## Application for Removal or Variation of a Condition following Grant of Planning Permission or Listed Building Consent

Erection of 1no. dwelling with double garage (following demolition of agricultural barn approved for conversion under DC/22/03389).

DC/22/05322

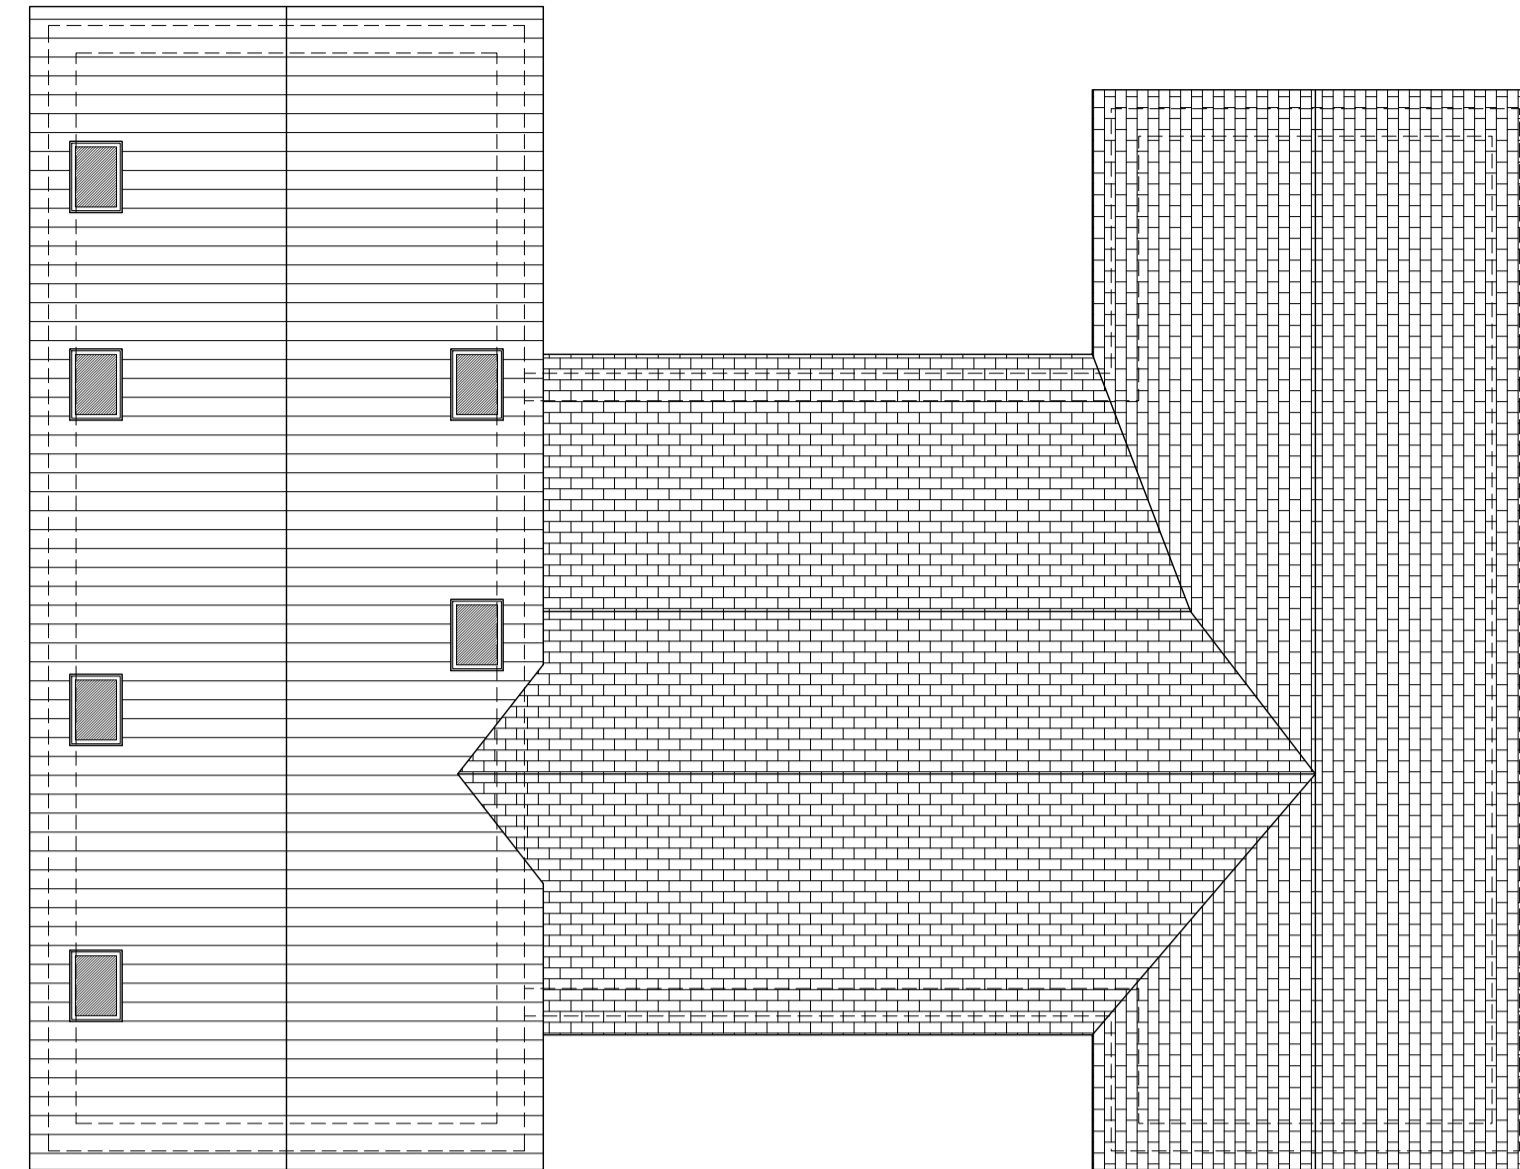
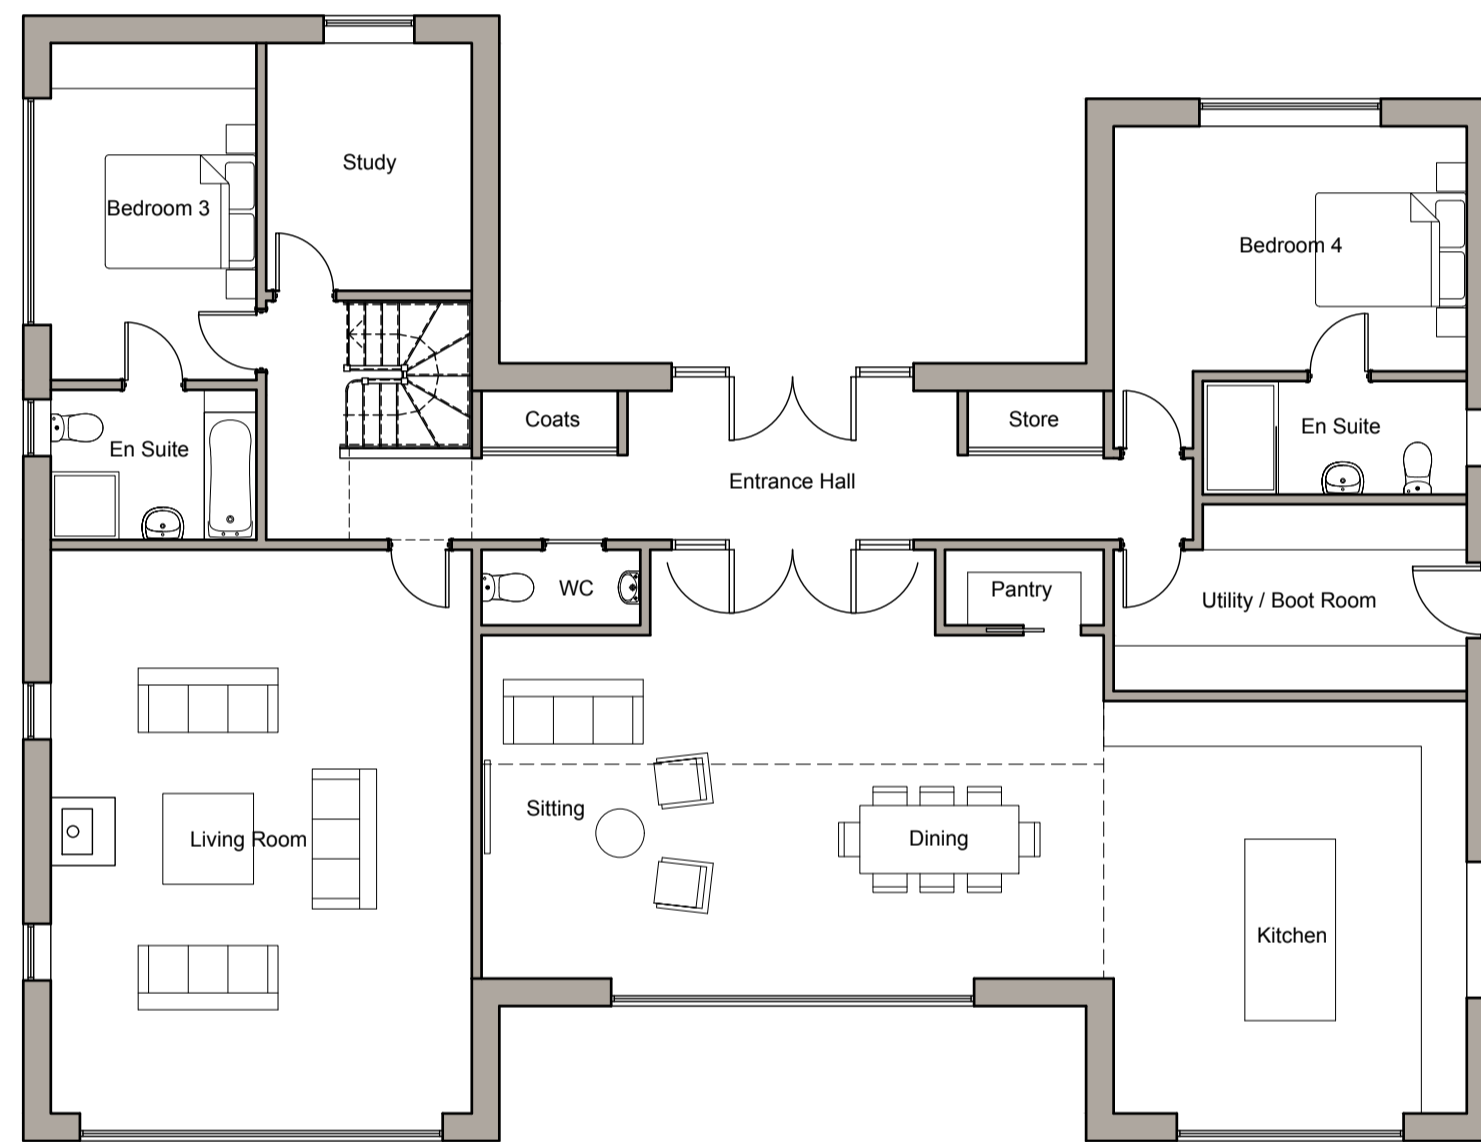
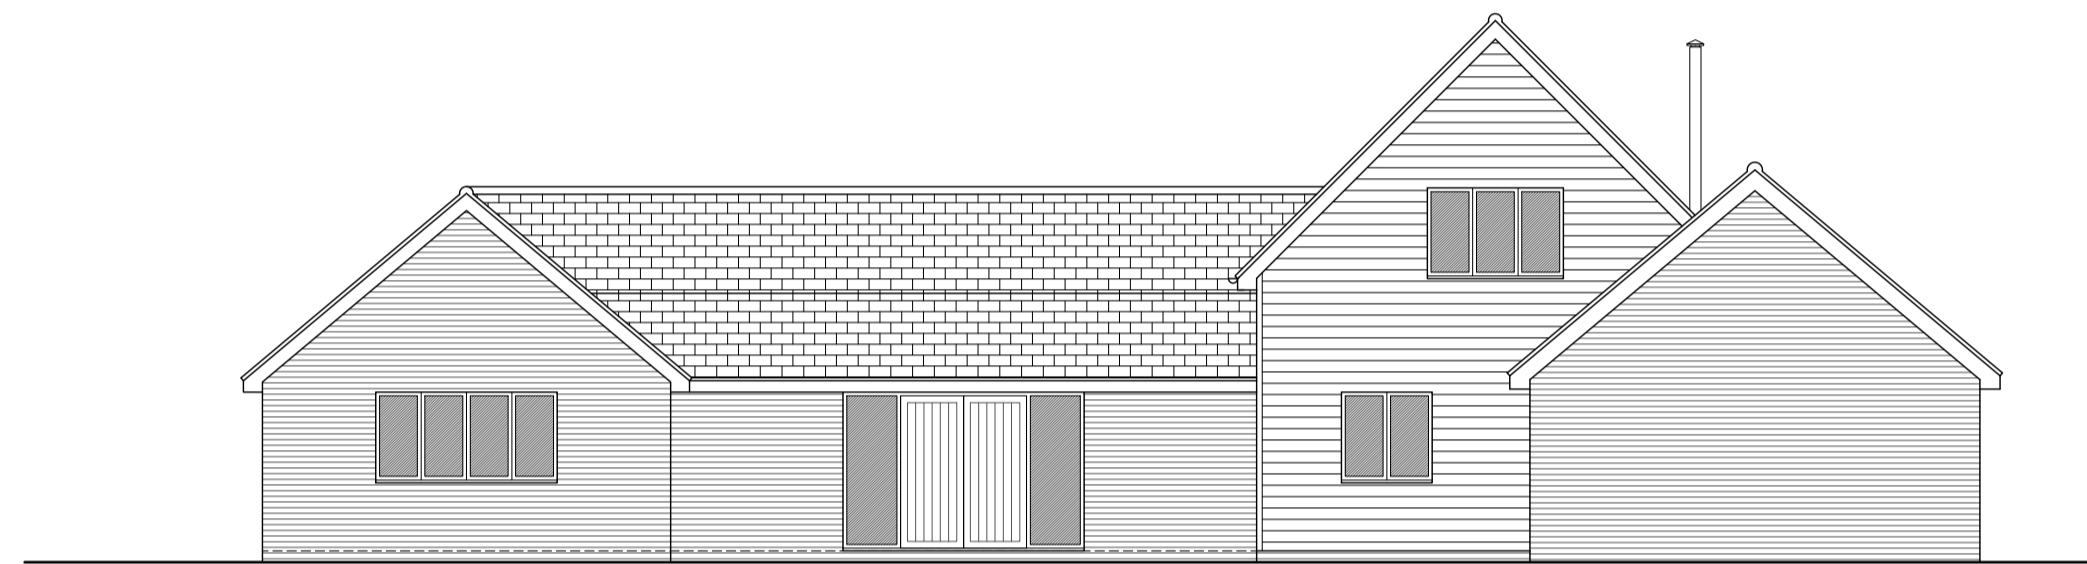
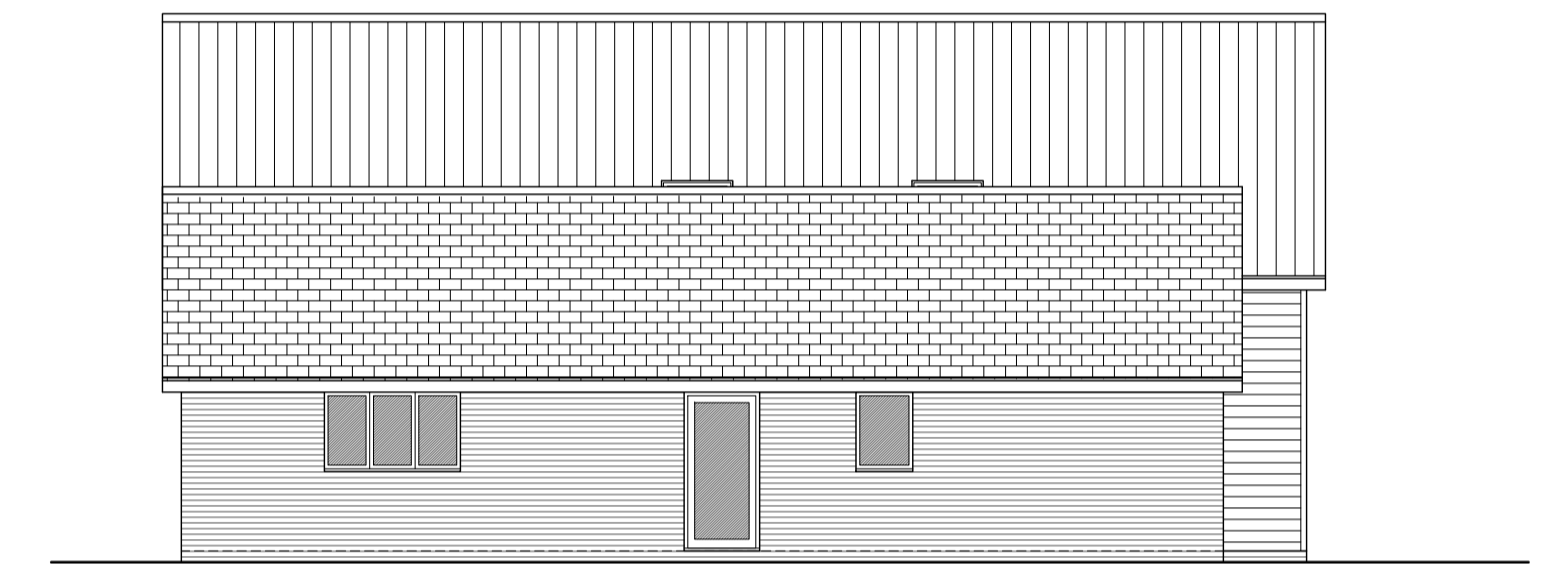
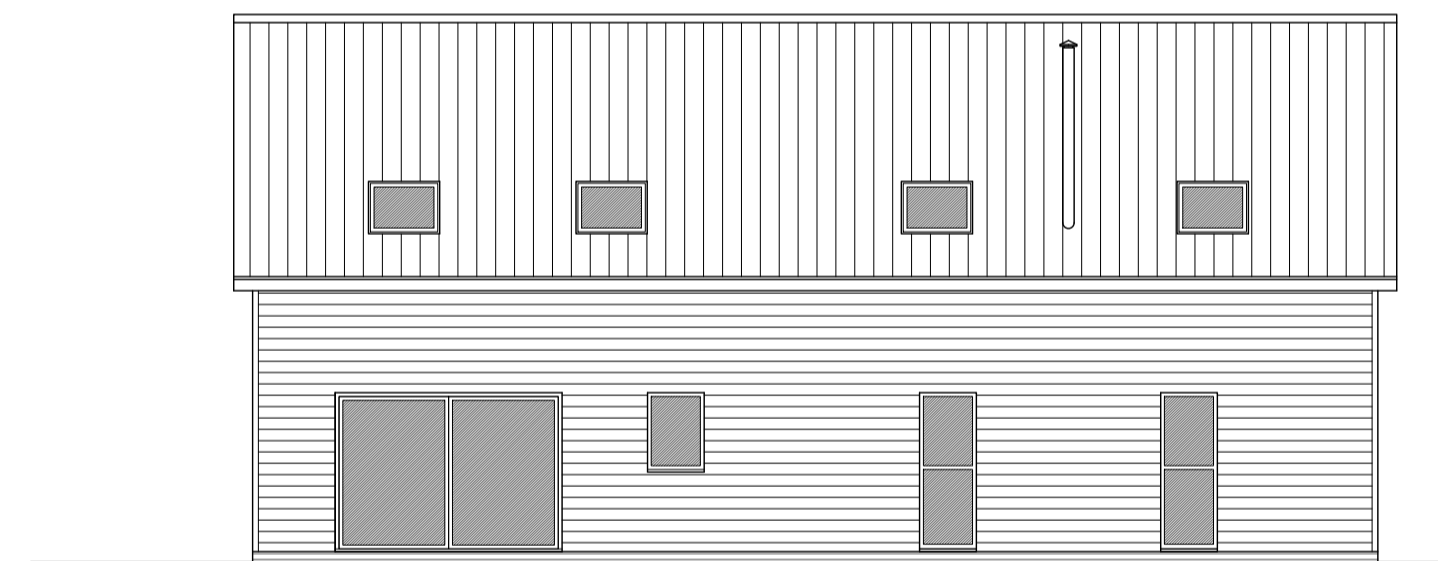
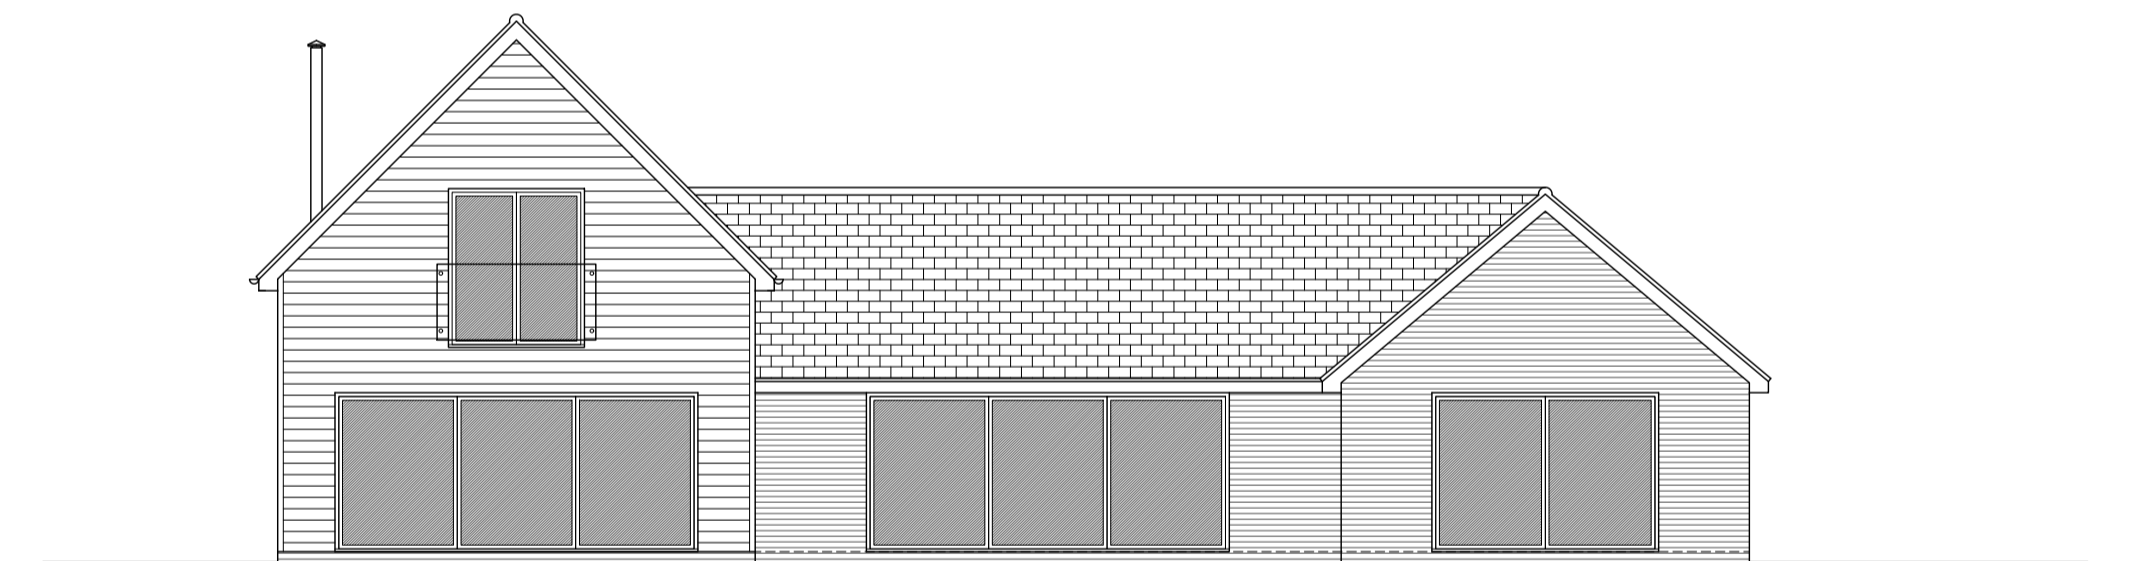
To make minor revisions to the proposed plans including; each side wing to be 2m longer to the rear, the middle section of the dwelling to be 1m wider, a new wood burner in the living room, and some internal layout changes.  
Please note that all eaves/ridge levels remain as approved.

Section A approved drawings to be amended as follows:  
Site Plan - Proposed PW1288\_PL03 to be replaced with PW1385\_PL100  
Plans - Proposed PW1288\_PL05 to be replaced with PW1385\_PL101
